Subject: SE-21-00025 Malsam - Notice of Application

TO: Community Development Services
FROM: Public Works Plan Review Team
DATE: November 10, 2021
SUBJECT: SE-21-00025 Malsam

SEPA Application Comments

MALSAM RESIDENCE
JEREMY MALSAM
GRADING & TESC PLAN

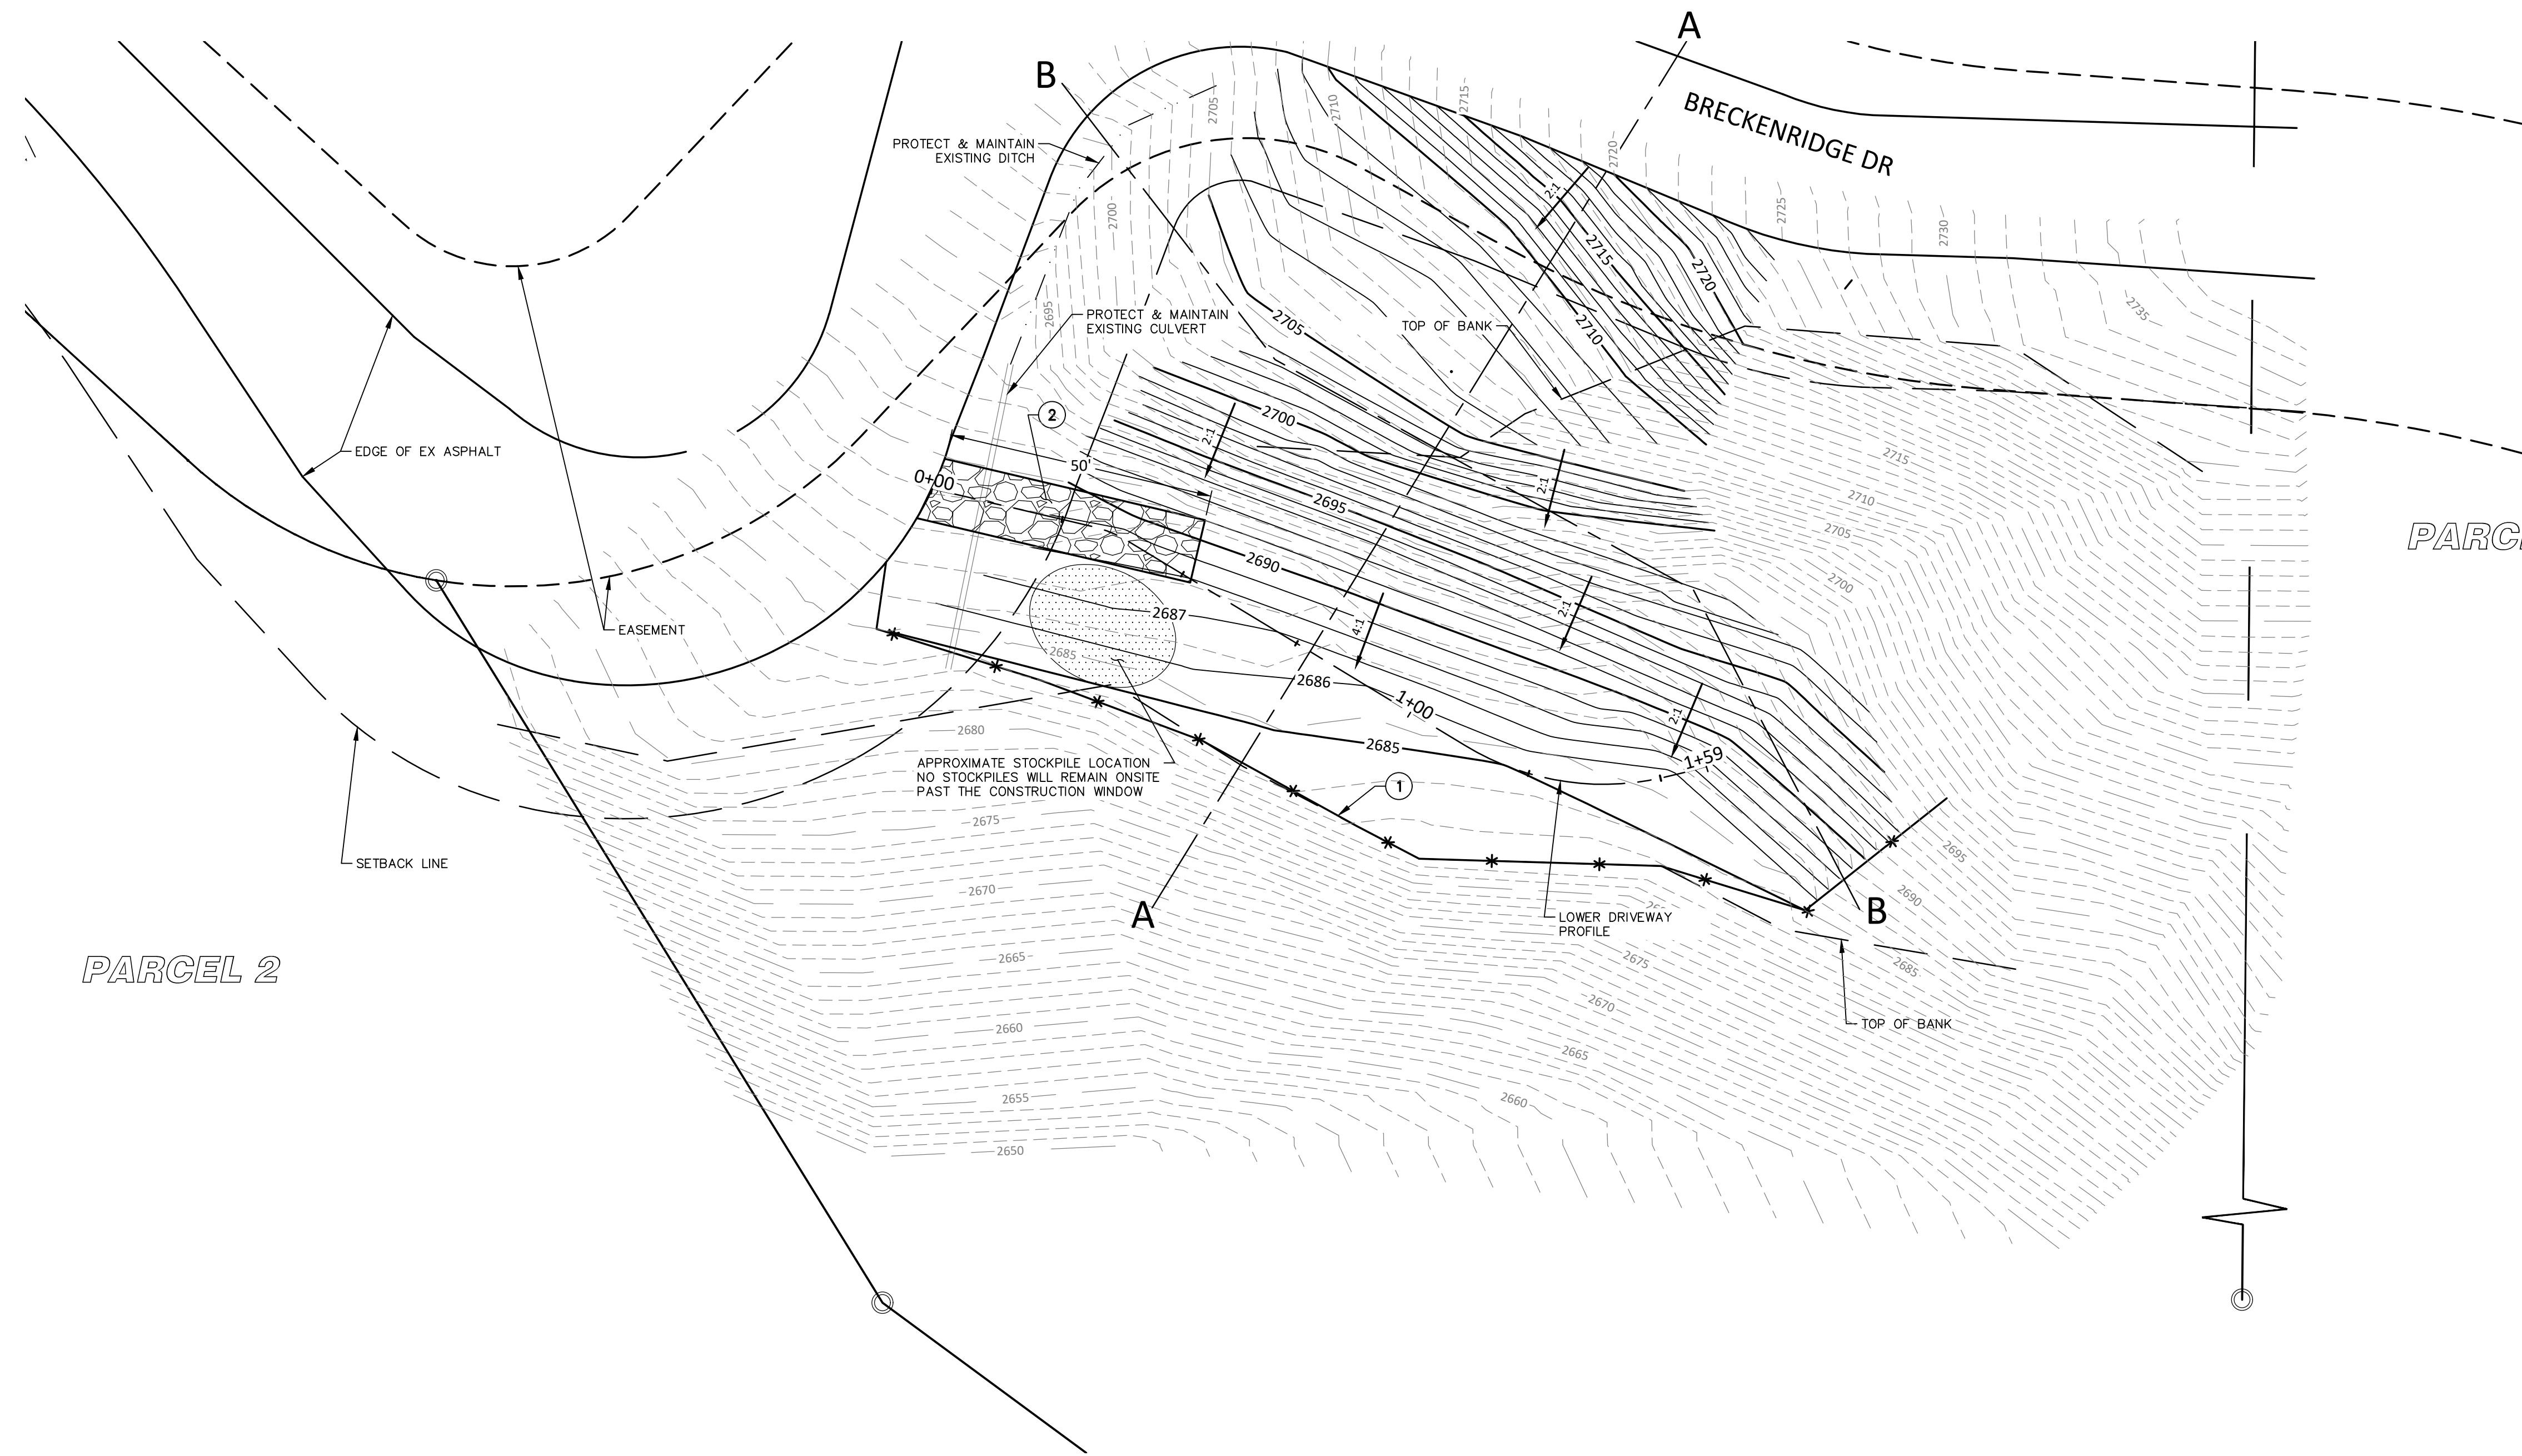
- An access/address permit will be required from Kittitas County Public Works prior to the issuance of a building permit for a future residence.
- The applicant has applied for the necessary engineered grading permit required for this project.
- Public Works has noted that a dispersion trench and a drain field have been placed at the southern top of bank for this property. The property owner will be responsible for any necessary mitigation as a result of any erosional effects caused by infiltrated/dispersed water.

MALSAM RESIDENCE
JEREMY MALSAM
SITE PLAN

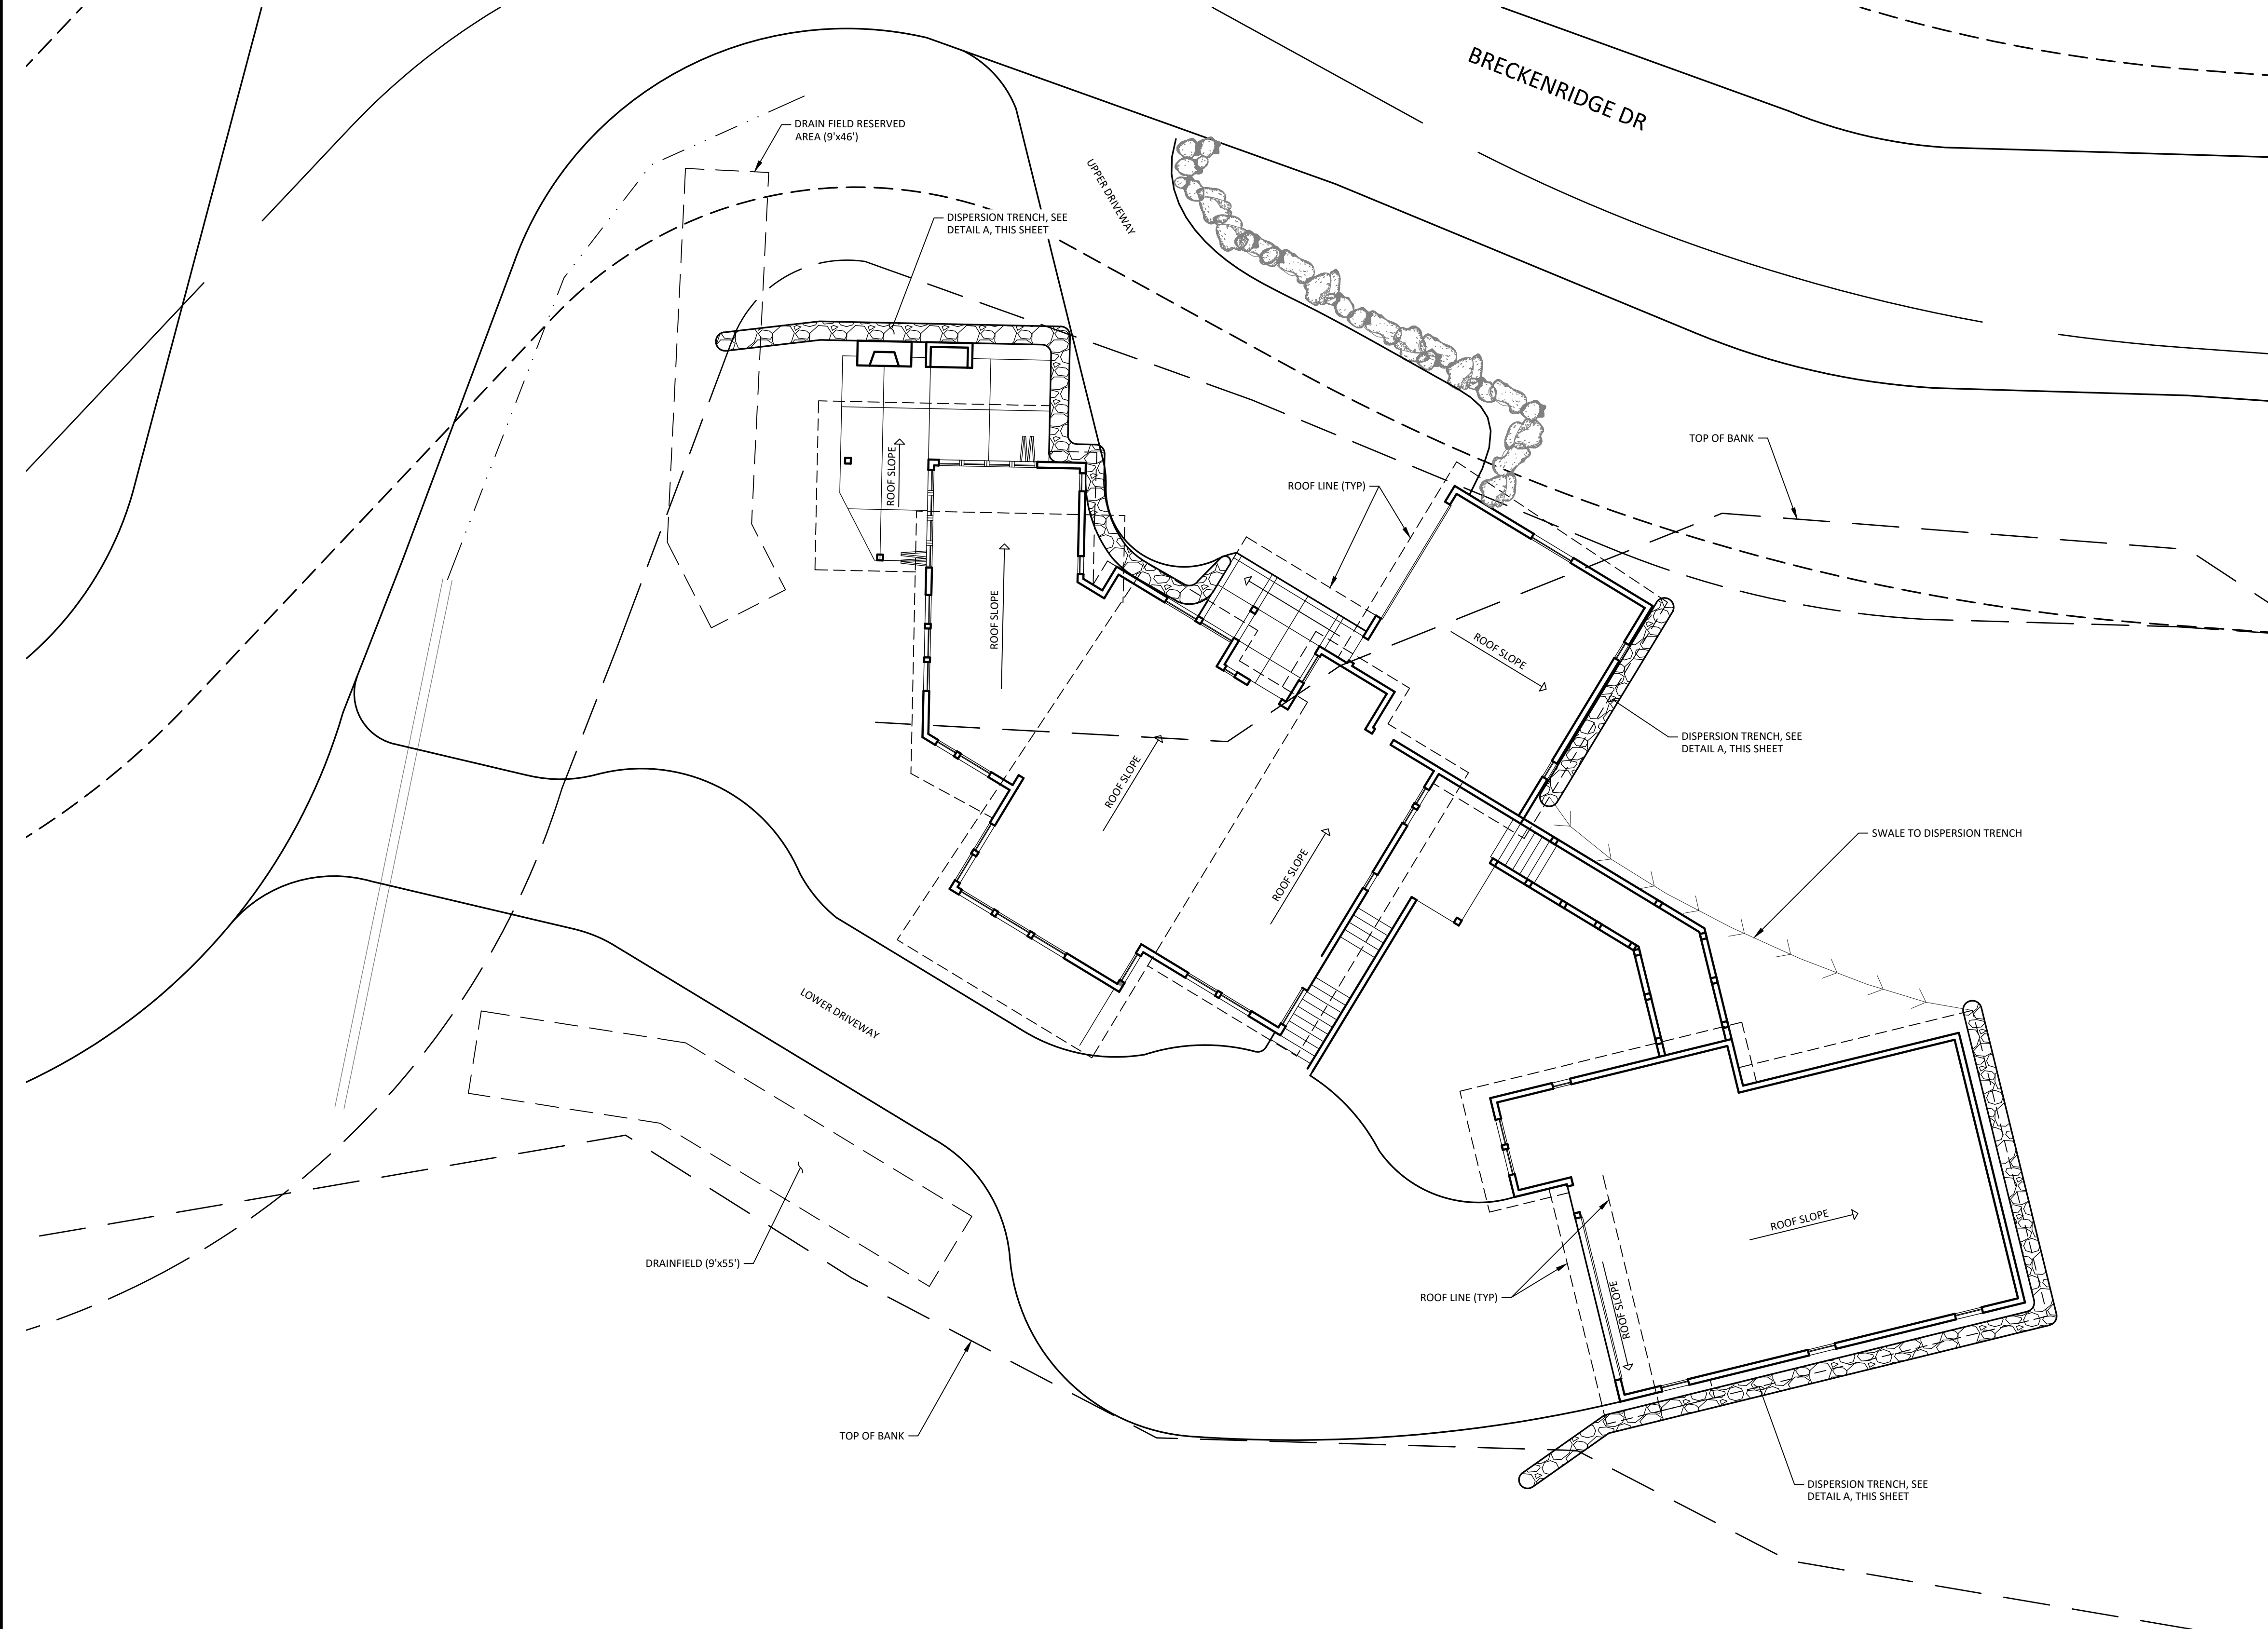
With the proposed house/garage and shop complex being moved 120 feet closer to the north property line, this leaves less room for the installation of the primary and reserve drain fields. The concern becomes if there will be adequate square footage for the drain fields. An additional concern is if the drain fields will be placed in the native soil with the grading and leveling taking place in the proposed building site. The existing design with our office has expired and with the proposed changes in this application and the locations of the structures, our office will be requiring another site evaluation and a re-design will be required as well.
